Application by Highways England for M54 to M6 Link Road

The Examining Authority's written questions and requests for information (ExQ1)

Issued on 20 July 2020

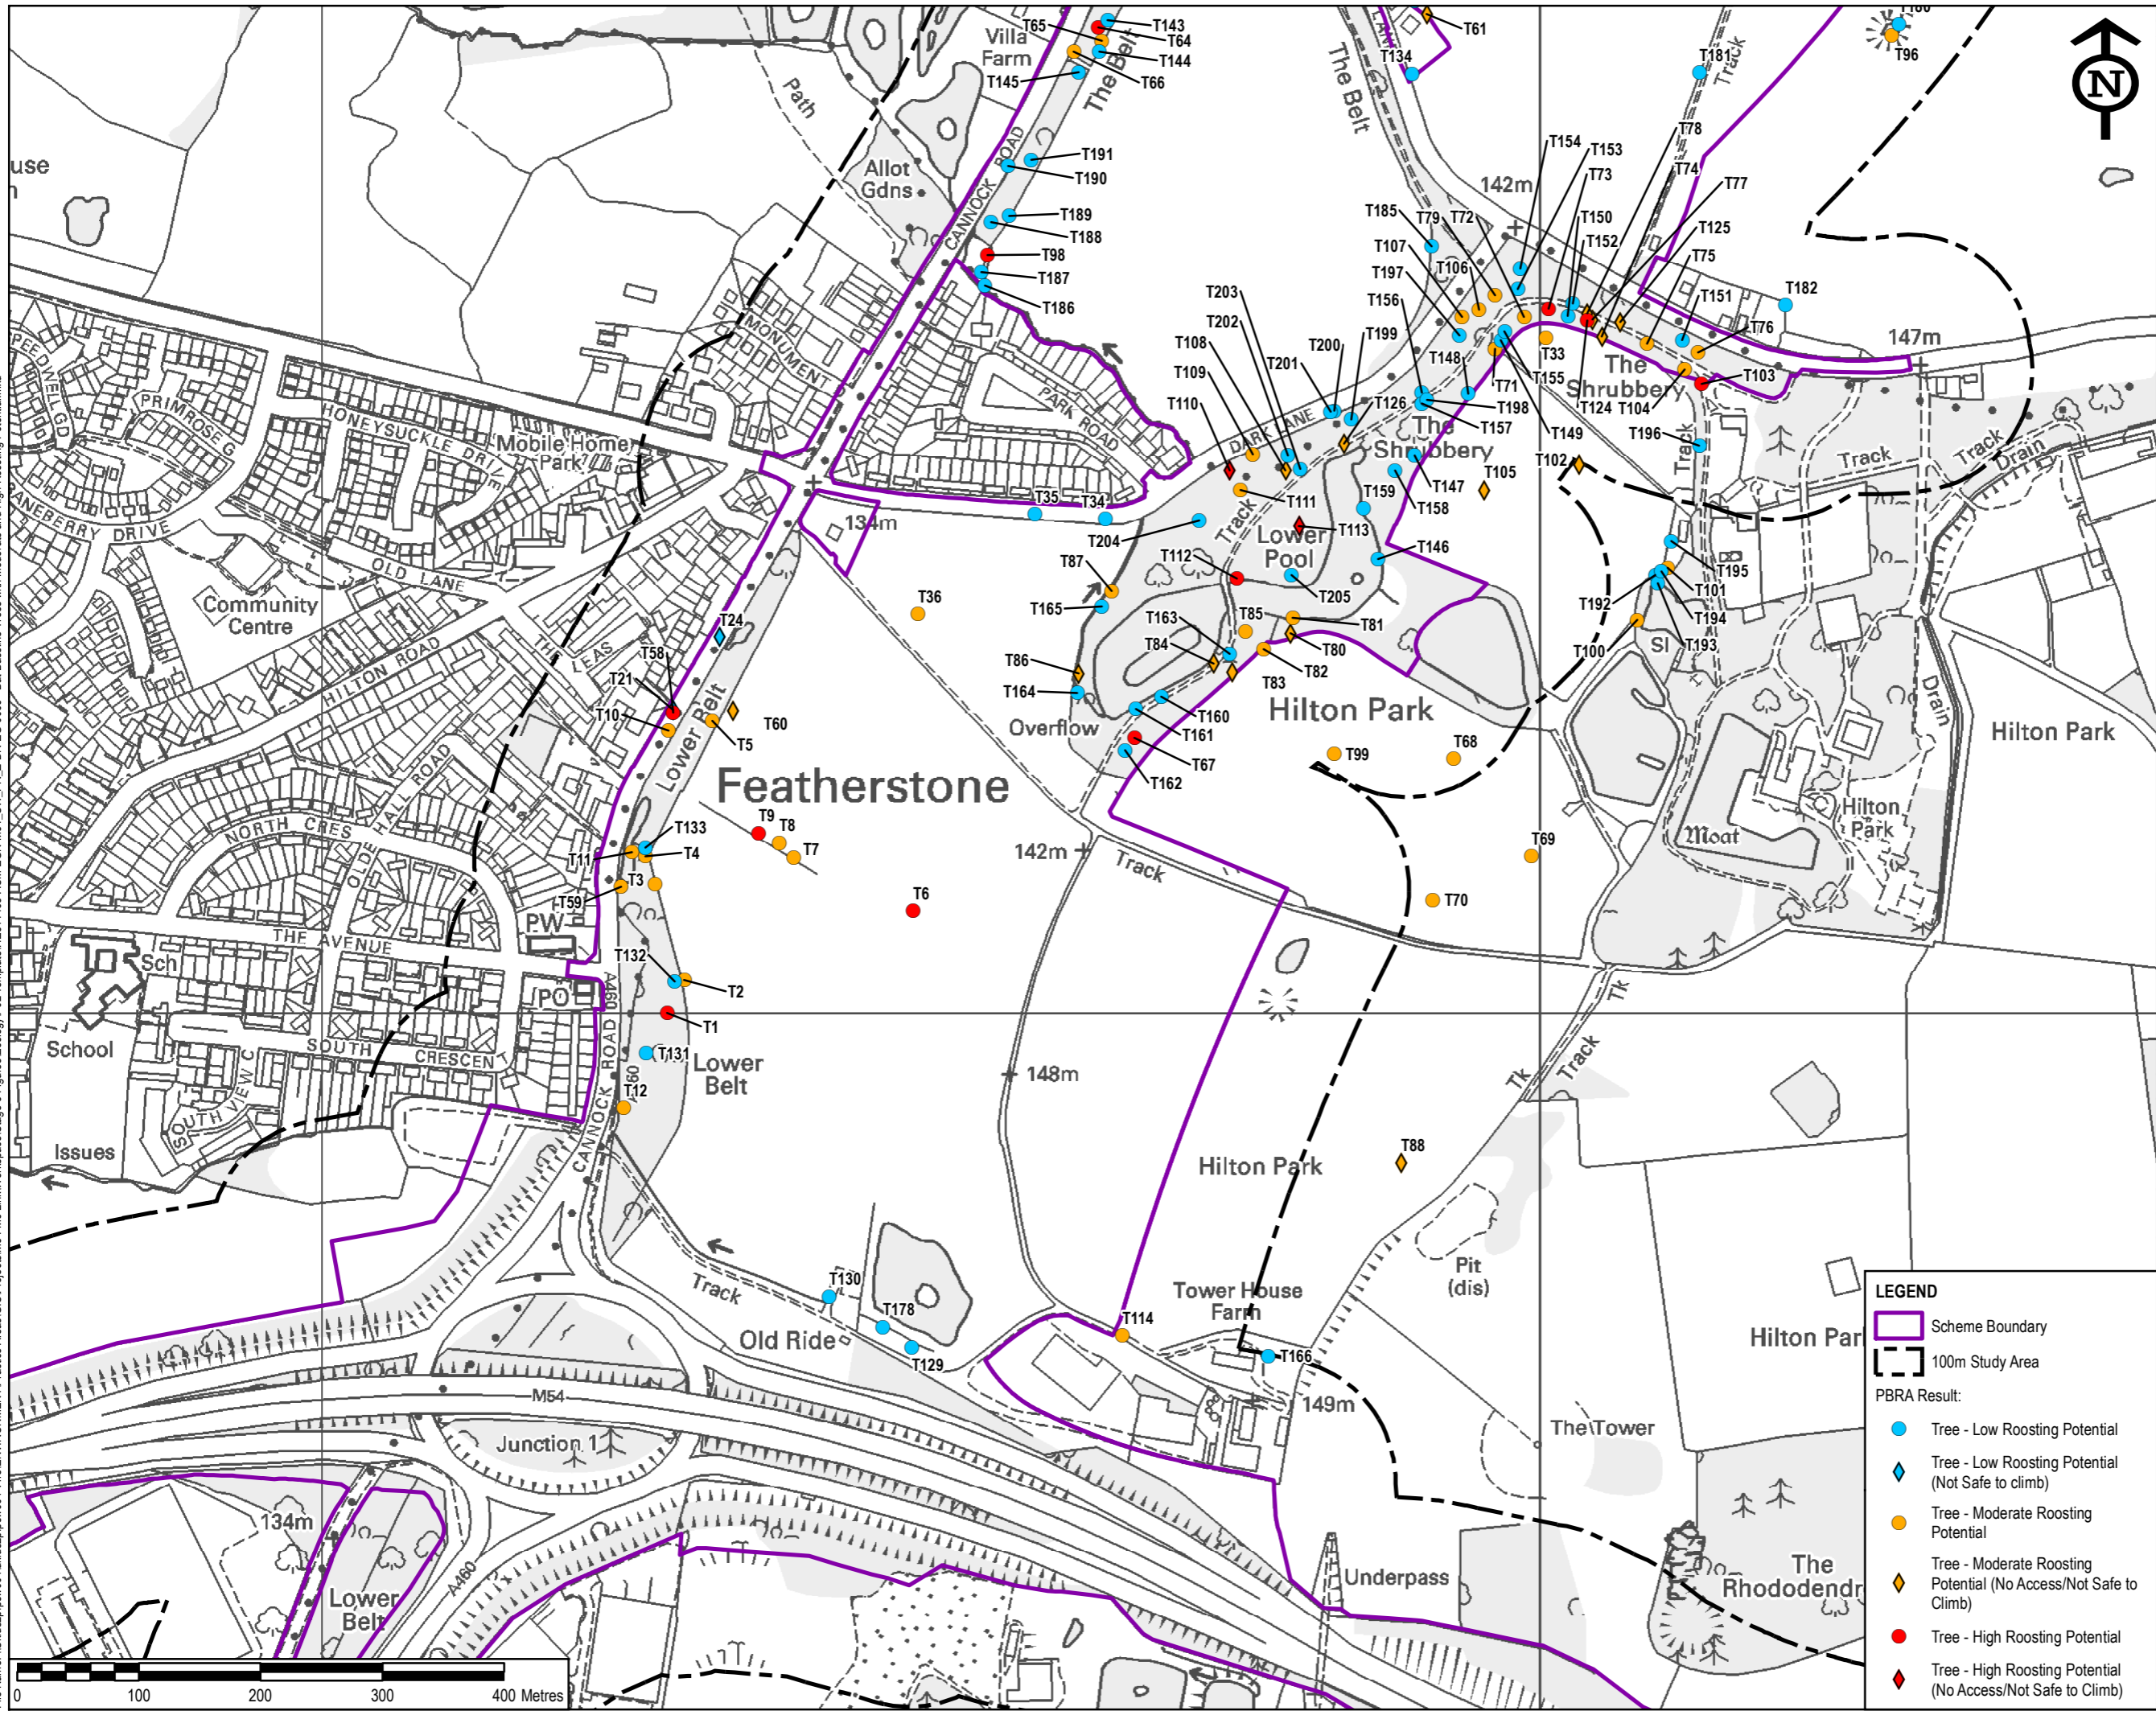
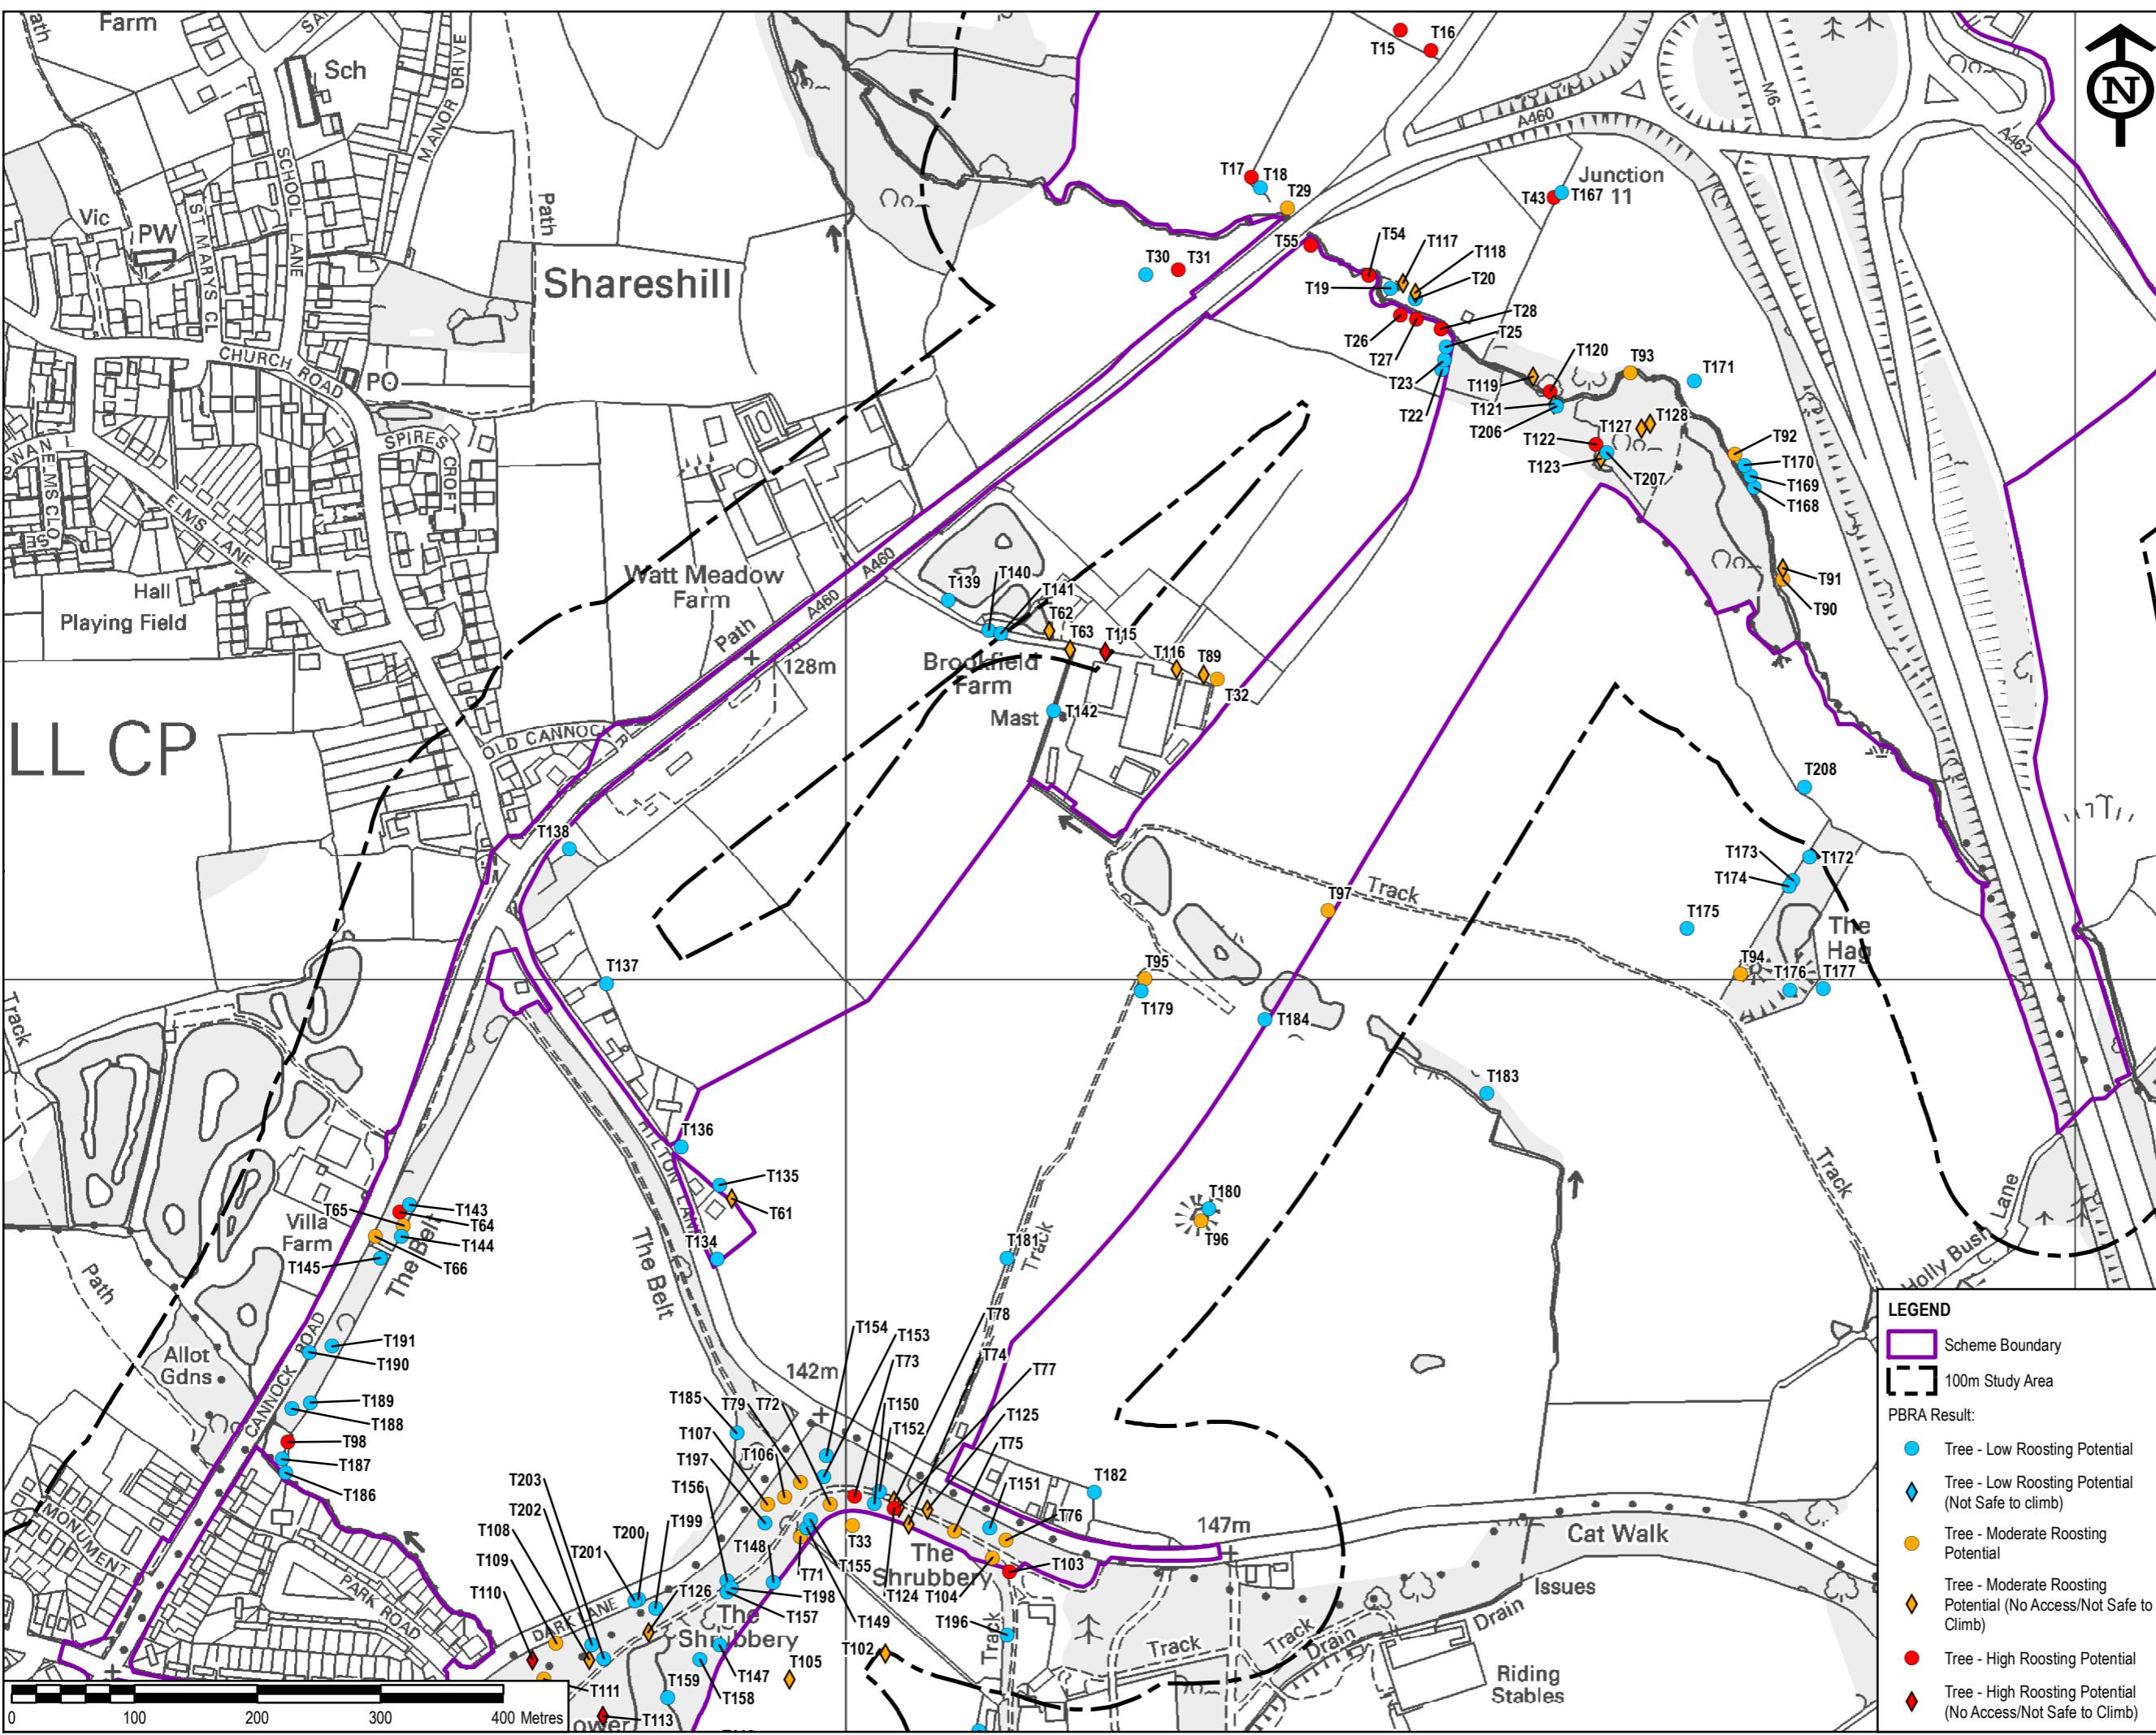
1.3.4.	The Applicant	Bats Paragraph 8.6.28 of Chapter 8 of the ES [APP-047] indicates two bat roosts within the boundary of the Proposed Development. However, in Figure 8.14 [APP-118] these two trees (T70 and T112) are given different classifications. Could this discrepancy be explained?
